From: [REDACTED]
To: Vasugi.Bradeepan
Subject: Re: 23/00723/FUL - Oakwood, Waterloo Road
Date: 29 November 2023 10:15:50
Attachments: [Oakwood_BoulderCoverElevations.pdf](#)

From: Vasugi Bradeepan <Vasugi.Bradeepan@bracknell-forest.gov.uk>
Sent: 23 November 2023 16:45
To: DC Minor <DC.Minor@Bracknell-Forest.gov.uk>; Basia Polnik
<Basia.Polnik@bracknell-forest.gov.uk>
Subject: 23/00723/FUL - Oakwood, Waterloo Road

Top, Front and Side elevation drawing of canvass boulder covering at Oakwood Youth Challenge.

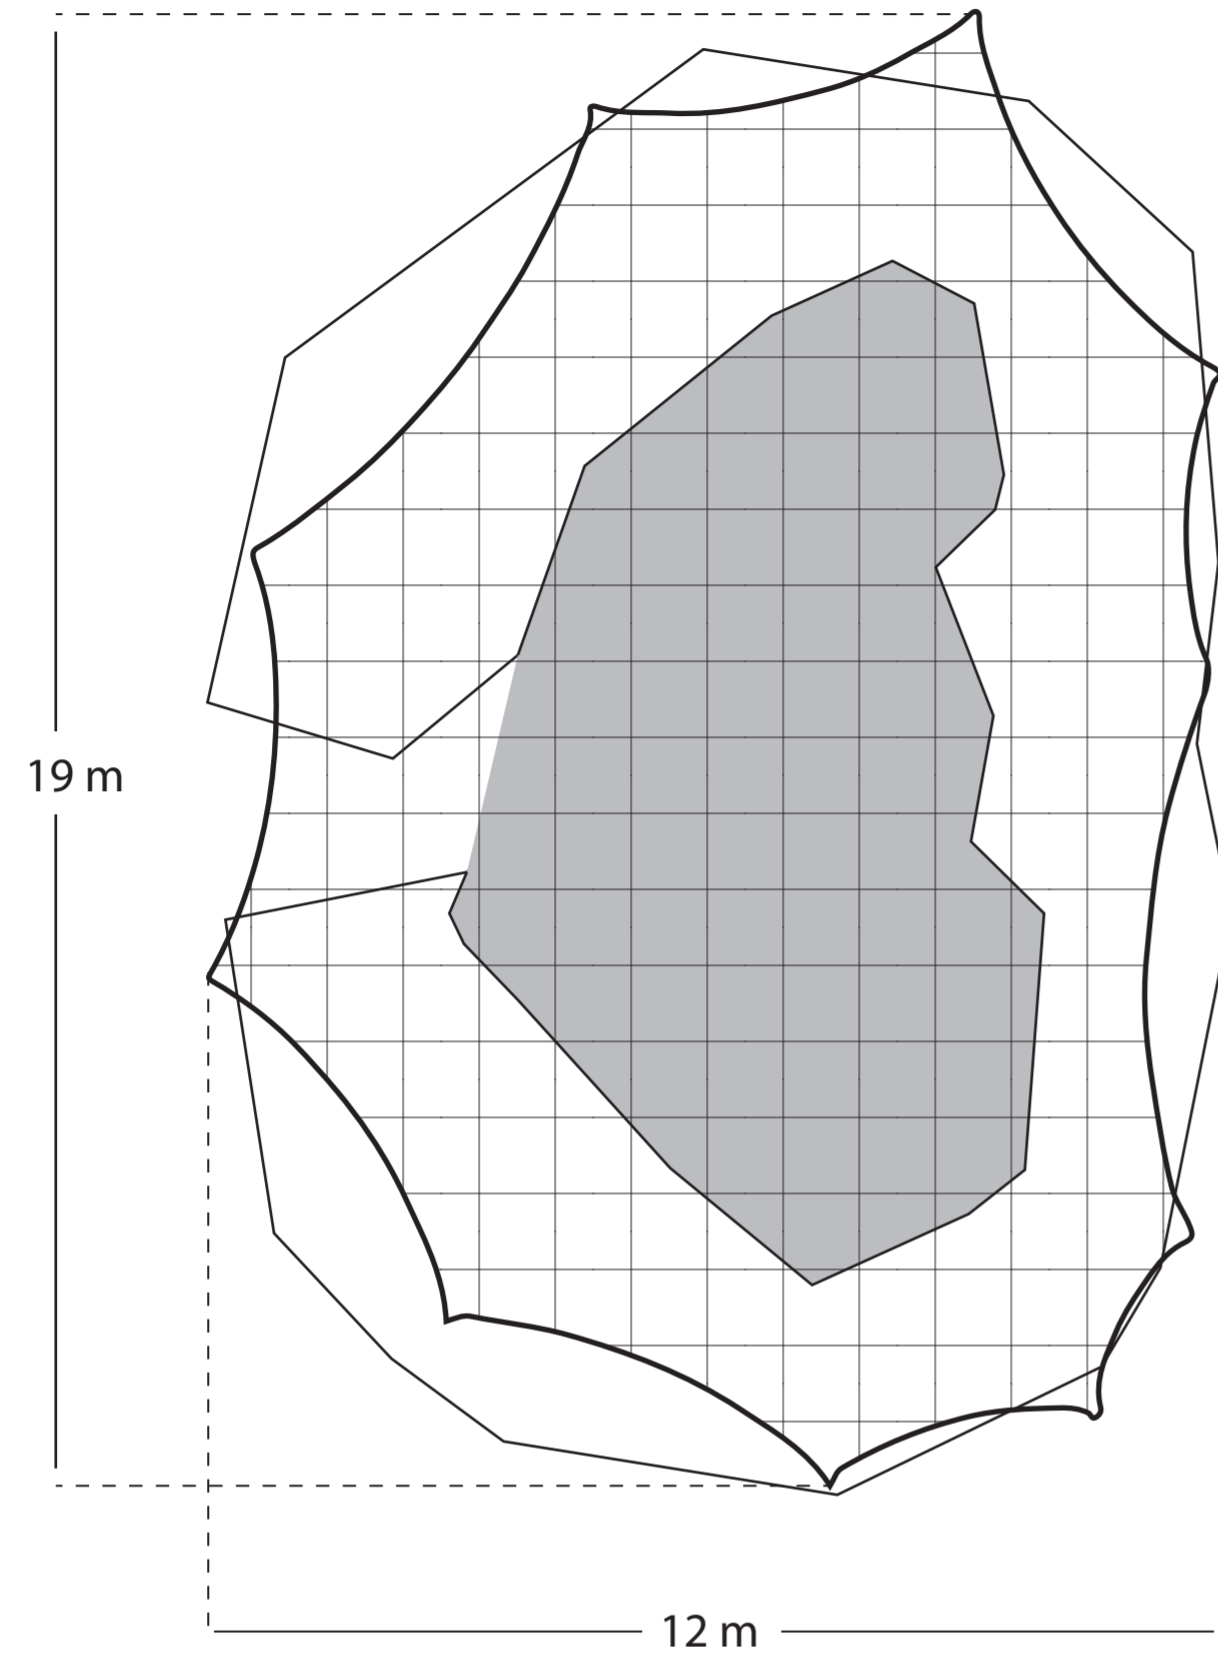
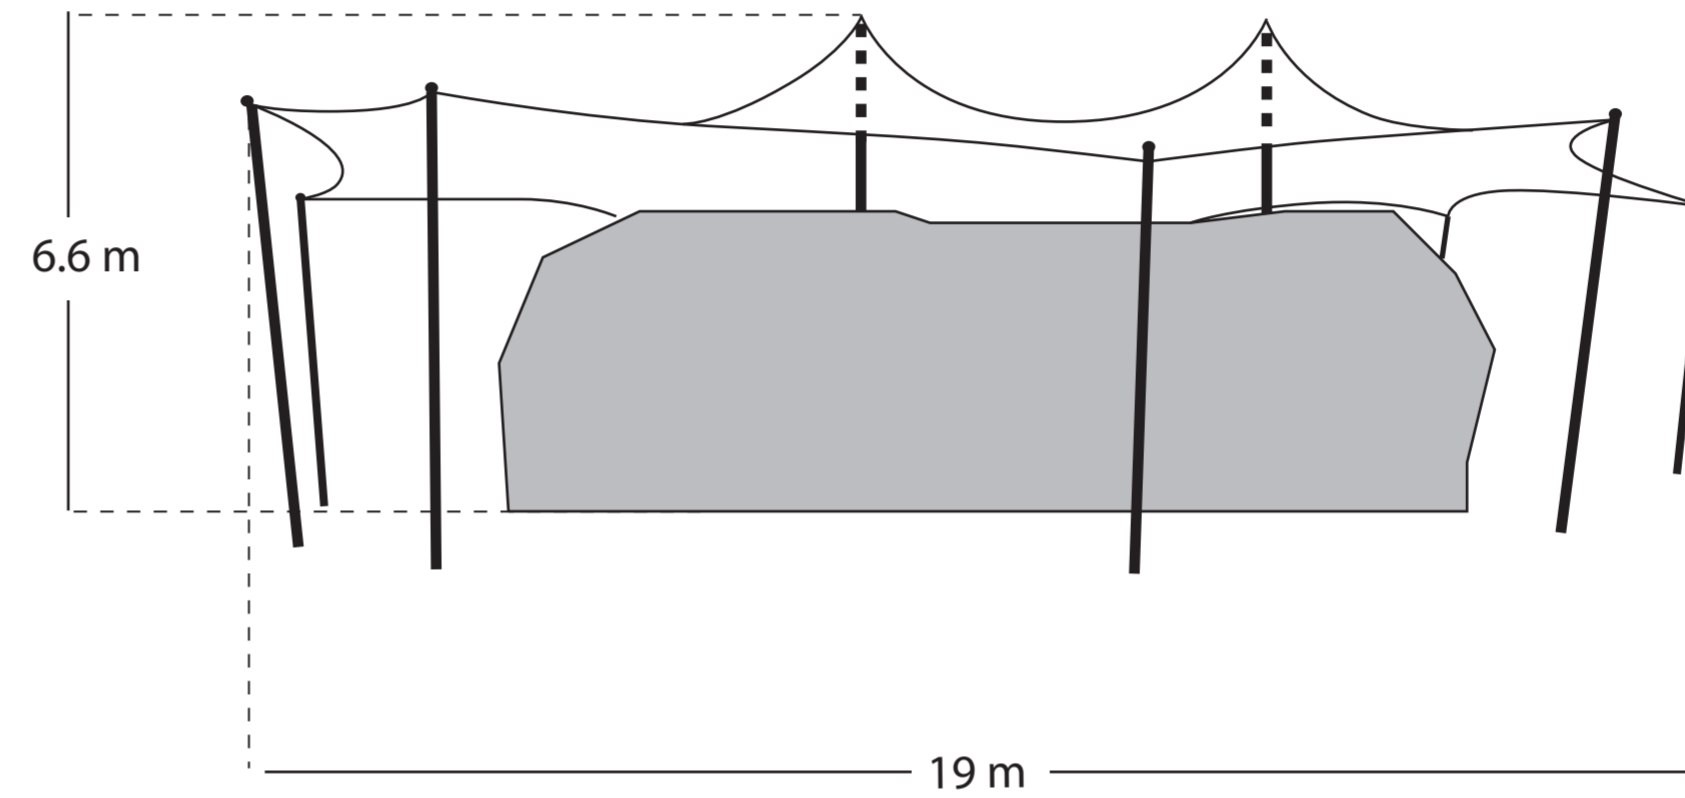
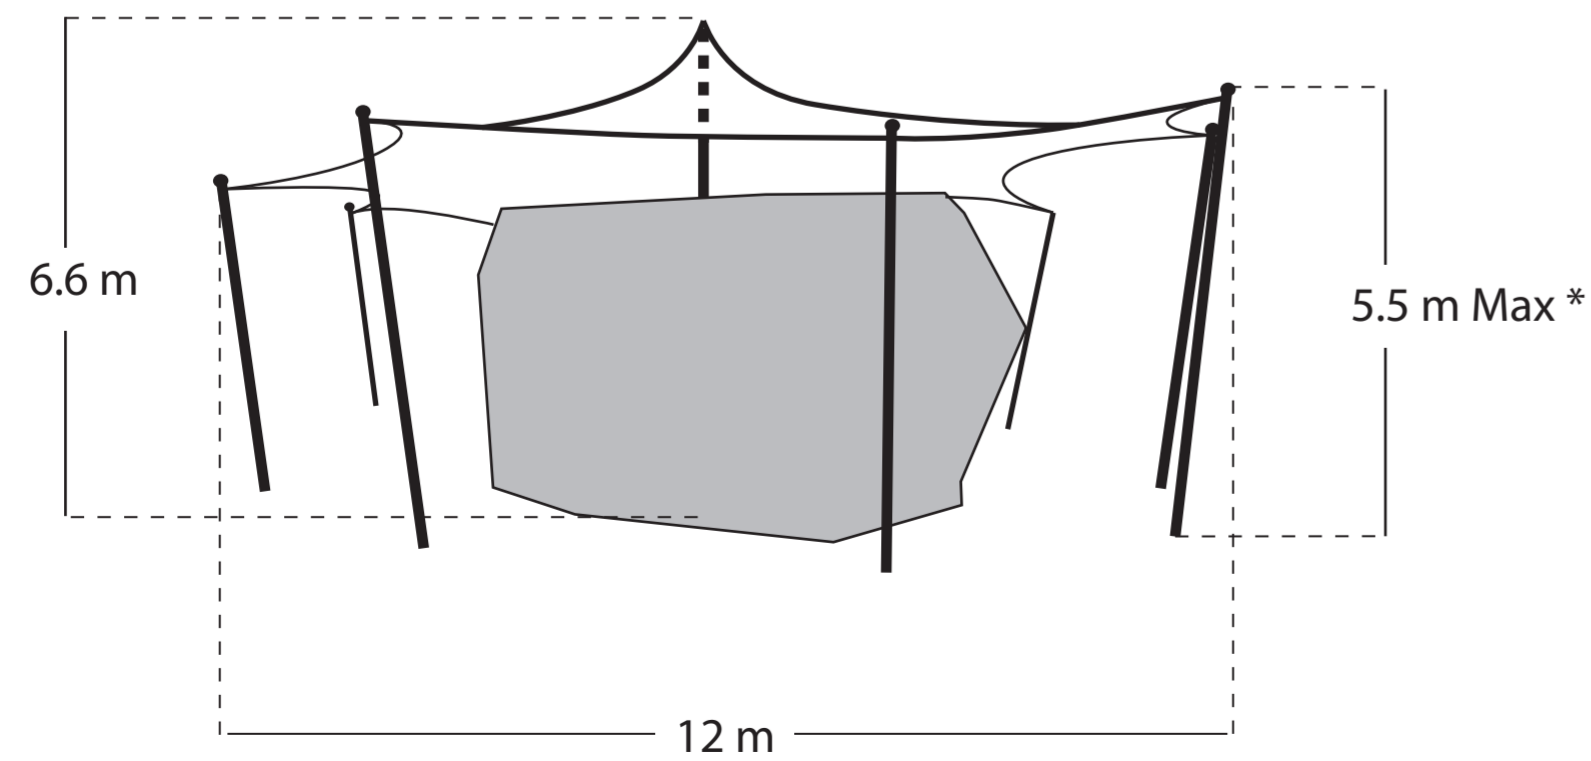
The development control manager requires the height to the top of the outside tent poles before she allocates it to a planning officer.

We have the maximum height of the canopy but please request the height to the top of the outside tent poles.

Please find attached amended elevations drawing.

Note, due to the nature of the structure the side poles vary in height between 4.5m and 5.5m in height, this is dependant on the angle of incline required to adequately tension the canvas.
